APPLICATION CONSULTATION RESPONSE

Application Number:	3/2018/0008
Location:	30 Peel Park Avenue, Clitheroe
Proposal:	Demolition of existing dwelling and erection of 34 bungalows for the over 55s with associated access, parking, landscaping and open space.

Objection 1 - Inadequate FRA:

Proposed Site Layout 1:500

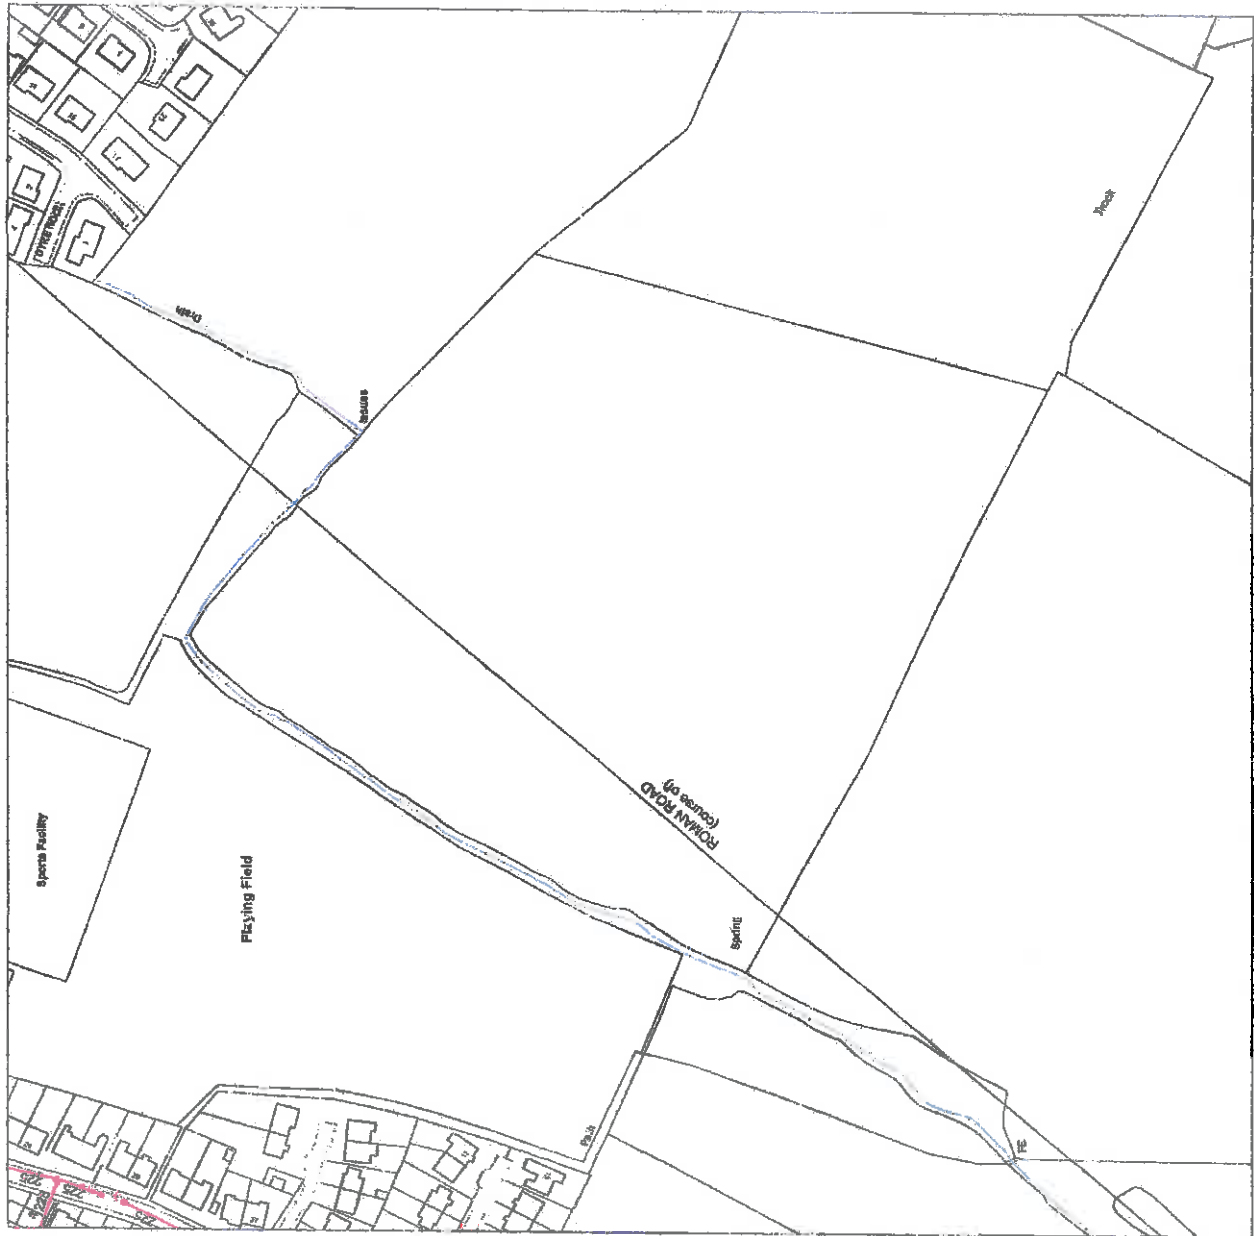
- a) Adequately assess the risk of surface water flooding to the site; specifically in regards to the surface water flood risk along the eastern and western boundaries of the site and the surface water flood risk around the proposed site access (including impacts on access/egress). The FRA also fails to provide sufficient details relating to mitigation measures that may be required in order to manage the risk of surface water flooding post development.

Whilst it is claimed in section 7 of FRA version 02 dated 07/12/17 that the existing ditch along the eastern boundary will mitigate the risk of overland flooding from higher land, it is noted that no evidence has been provided to substantiate this claim.

- b) Adequately assess the risk of flooding from various sources that are known to be within or on the site boundary. This includes both open watercourses and the spring to the North West corner. The FRA also fails to provide sufficient details relating to mitigation measures that may be required in order to manage the risk of from these sources of flooding (including providing access for future maintenance).

- c) Sufficiently demonstrate that surface water can be safely managed for the lifetime of the development. It is noted that the applicant intends to dispose of surface water via an existing watercourse that is located along the western boundary of the site. Insufficient details have been provided regarding this watercourse and therefore it is unknown whether it is sufficiently sized and in a sufficient condition to accept the flows that will be generated from the site. The FRA should also provide an Indicative drainage plan which includes the location of the proposed outfalls.

You can overcome our objection by submitting an FRA which covers the deficiencies highlighted above and that demonstrates that the development will not increase flood risk elsewhere and where possible reduces flood risk overall. If this cannot be achieved then we are likely to maintain our objection to the application. Production of a revised FRA will not in itself result in the removal of an objection. The additional evidence requested will also need to be provided.
